Application for a Non-Material Amendment Following a Grant of Planning Permission

Application for approval of reserved matters (Appearance, Landscaping, Layout and Scale) relating to plot 3 of planning permission P0520/17/OUT

P1401/22/APP

Non Material Amendment No. 1 – Clarification of external materials used

TITLE: Proposed Site Plan A1

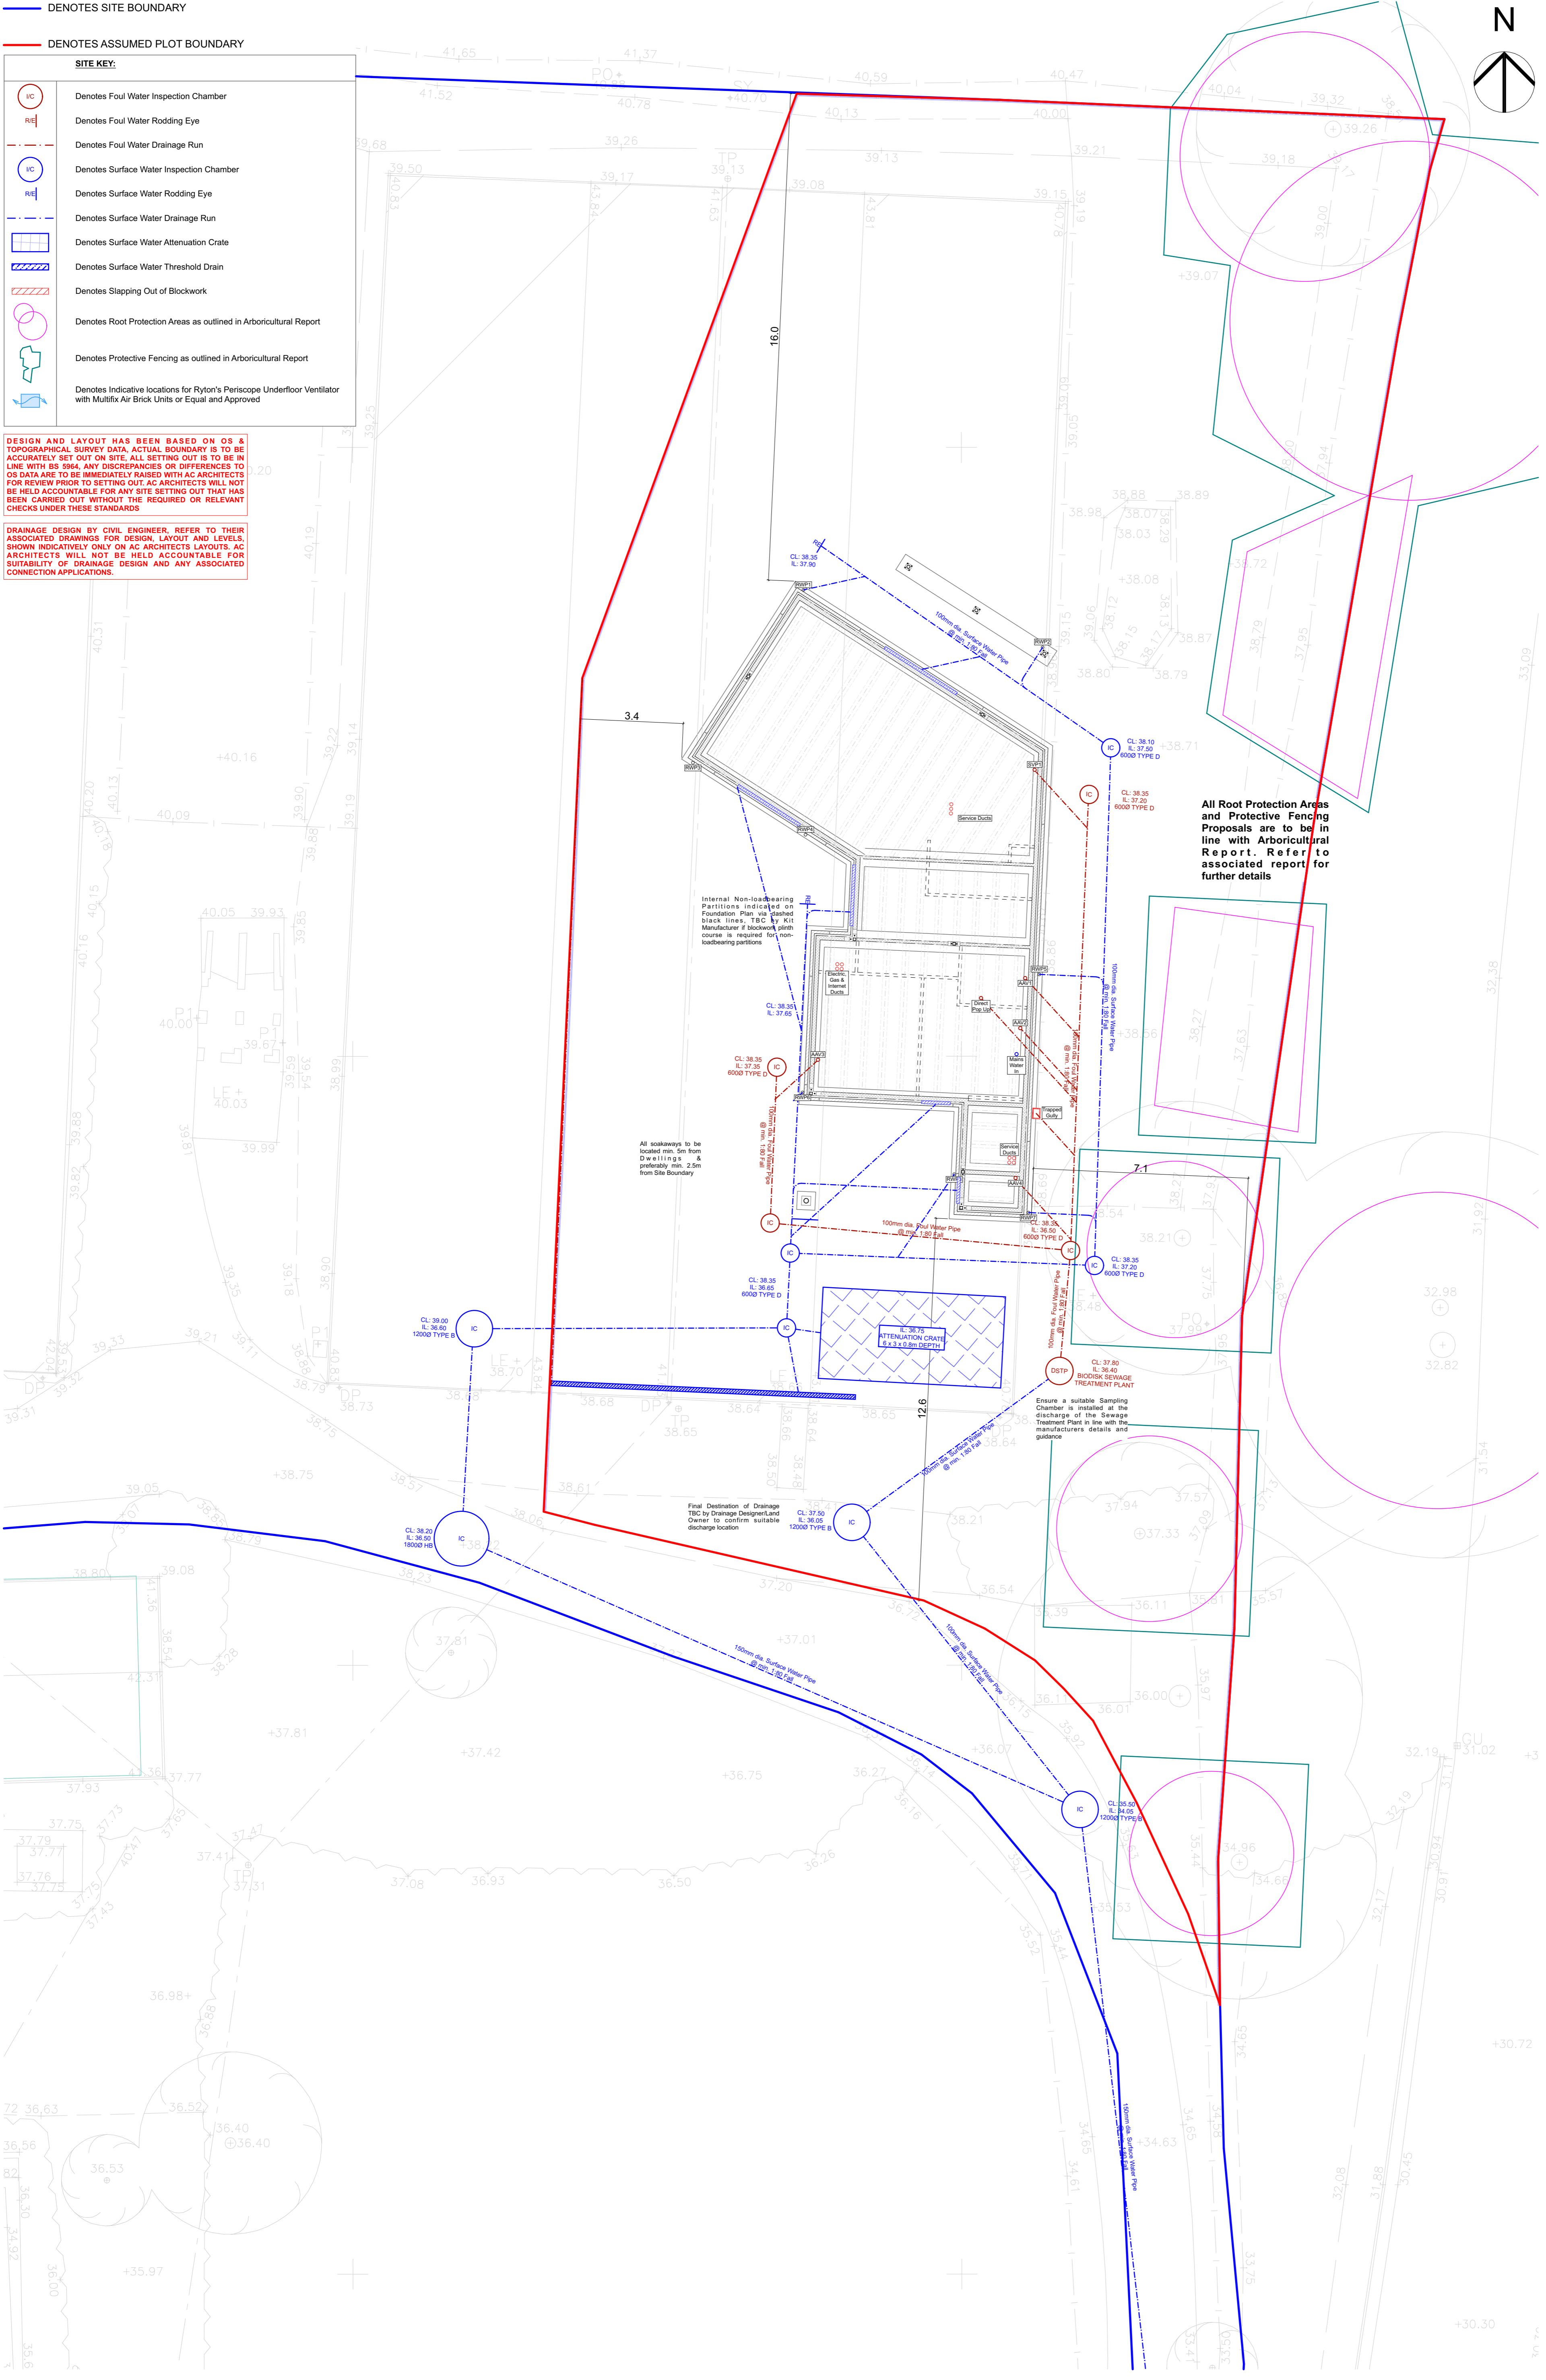
Non Material Amendment No. 2 – Updates to surface drainage attenuation

NMA 2 - The previous scheme included a single attenuation tank for all three plots within the original planning permission. Each plot will now have its independent attenuation tank. The size and location of the tank previously indicated on Plot 3 has therefore reduced in size and shifted away from the drive as attached drainage drawing and rainwater calculations.

448 - BC 102A Proposed Site Plan
C001 Revision B - Drainage Layout
